**PRELIMINARY DRAINAGE REPORT  
FOR  
STERLING RANCH PHASE 2 PRELIMINARY PLAN**

**Engineering Review**

**October 1, 2020  
Project No. 25188.02  
SP-20-003**

# STERLING RANCH PHASE 2 PROPOSED DRAINAGE MAP

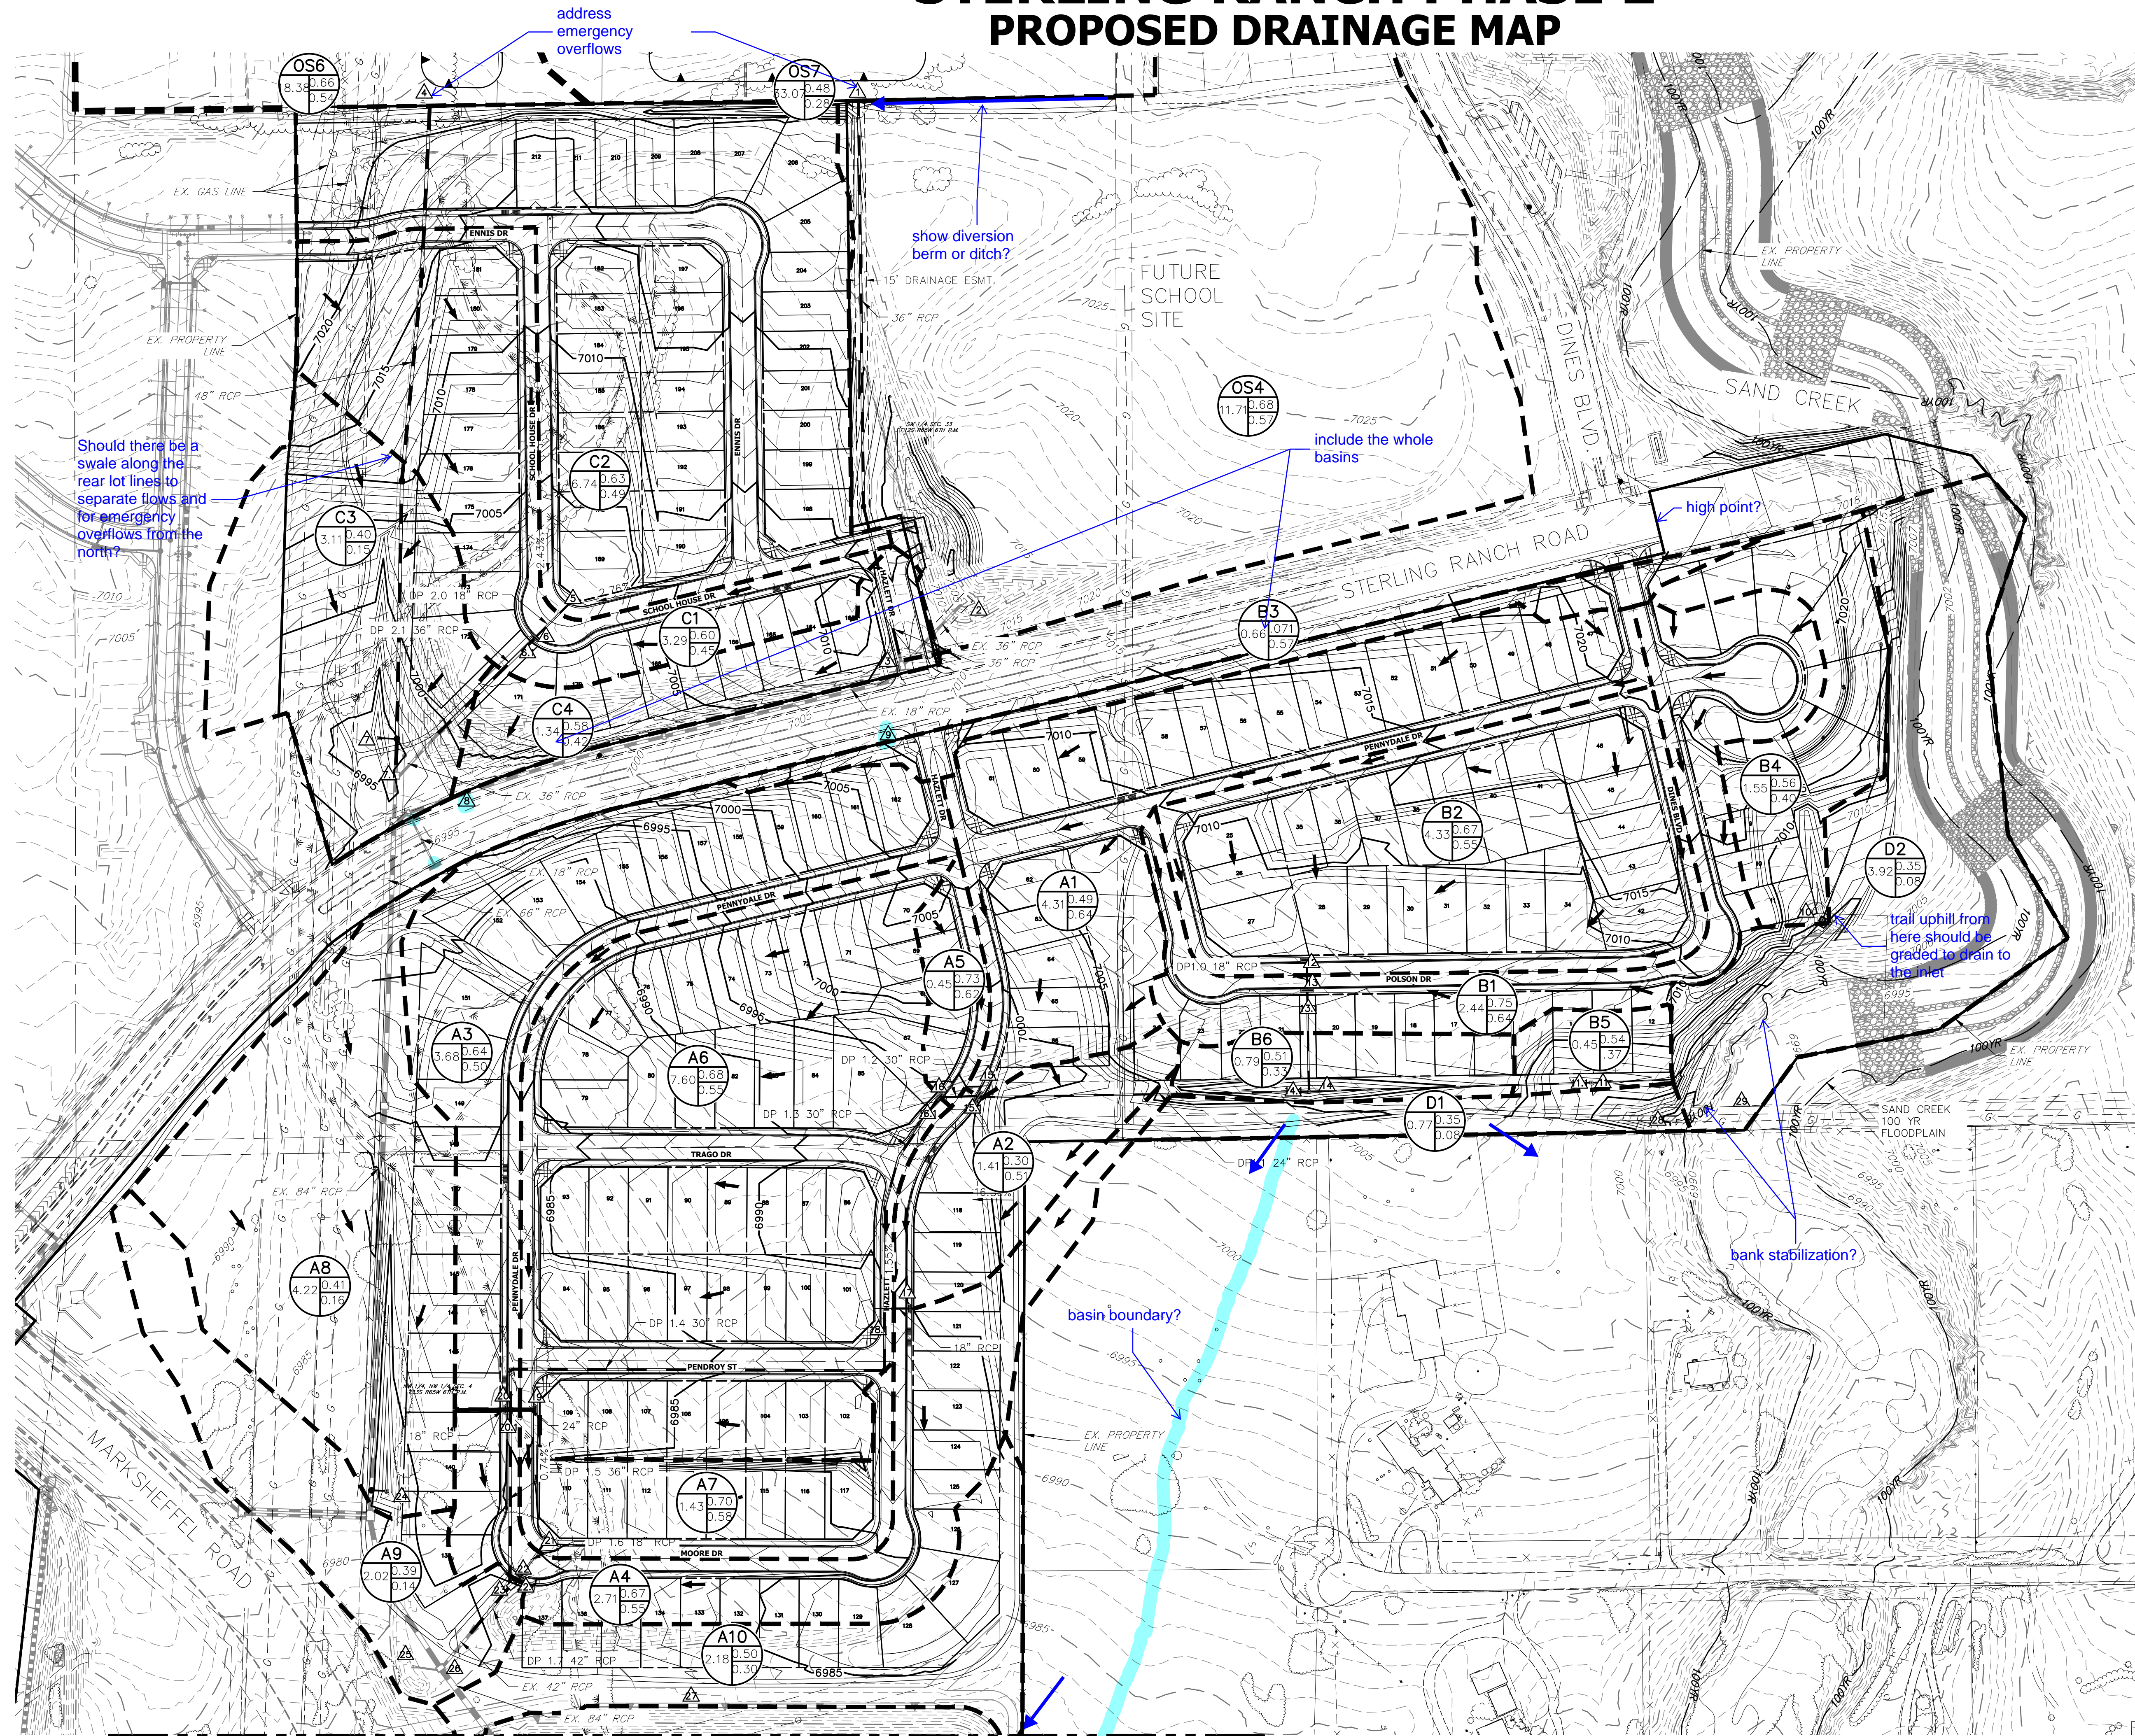
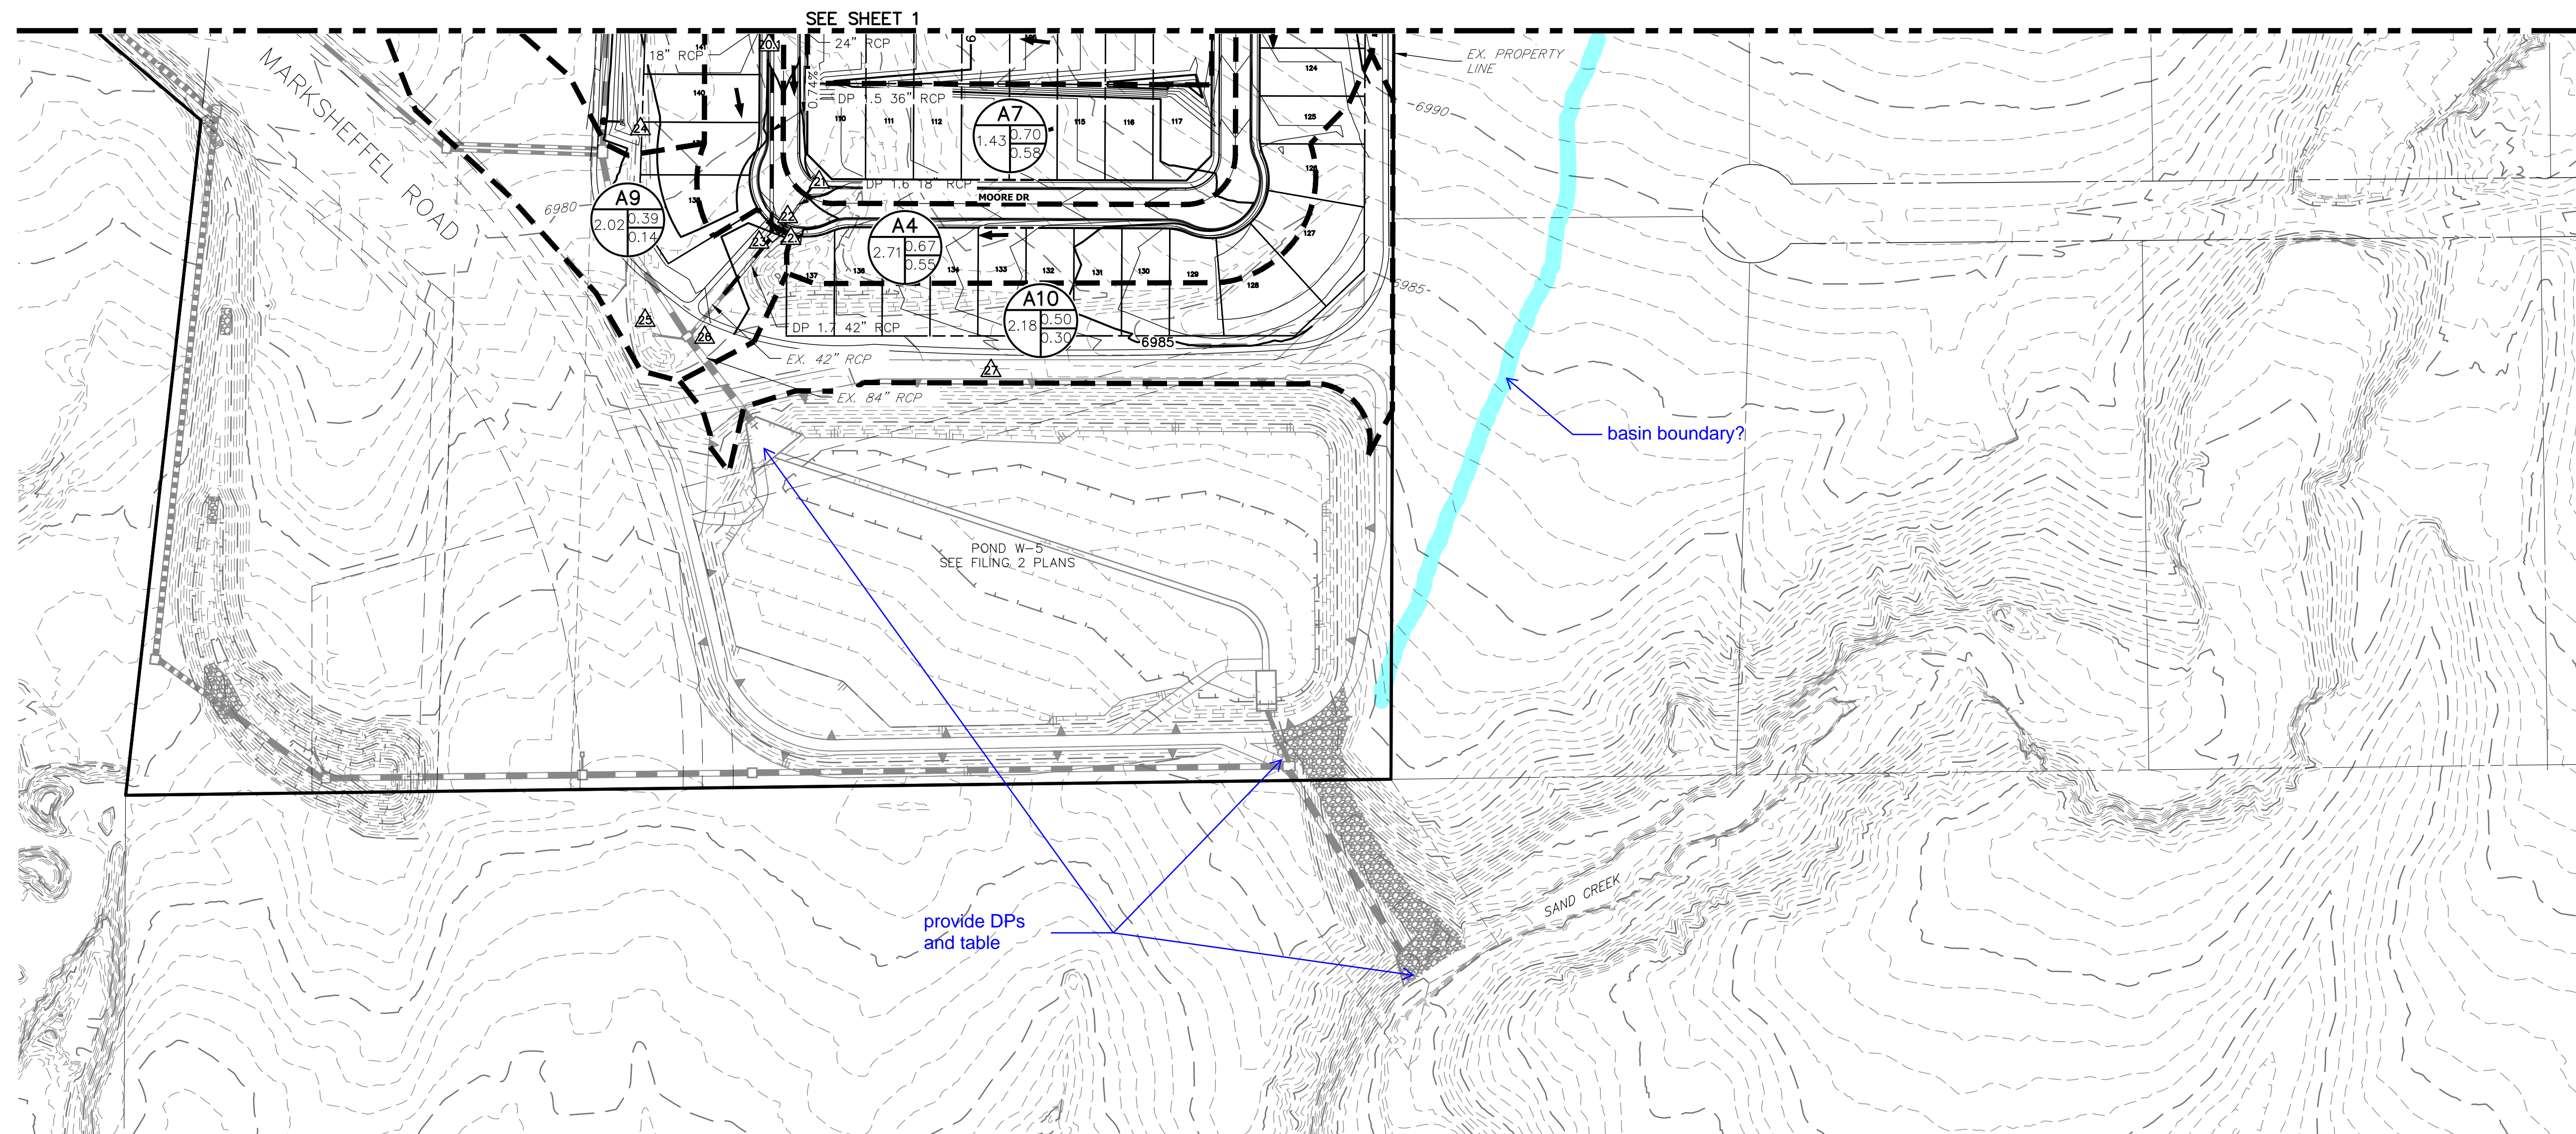
15?

basin?

bypass?

17?

basin?

20?

22?

bypass?

16?

19?

pipe

21?

24?

25?

13?

12?

adjust plan location?

adjacent properties and

southwest and (?)

4?

1?

JR Response: Yes, upstream bypass flows

JR Response: updated

JR Response: Updated

JR Response: Updated

JR Response: Updated

JR Response: Updated

JR Response: Updated

JR Response: Updated

JR Response: Updated

JR Response: Updated

JR Response: Updated

JR Response: Updated

JR Response: Updated.  
Southeast only.

JR Response: Updated

JR Response: Updated
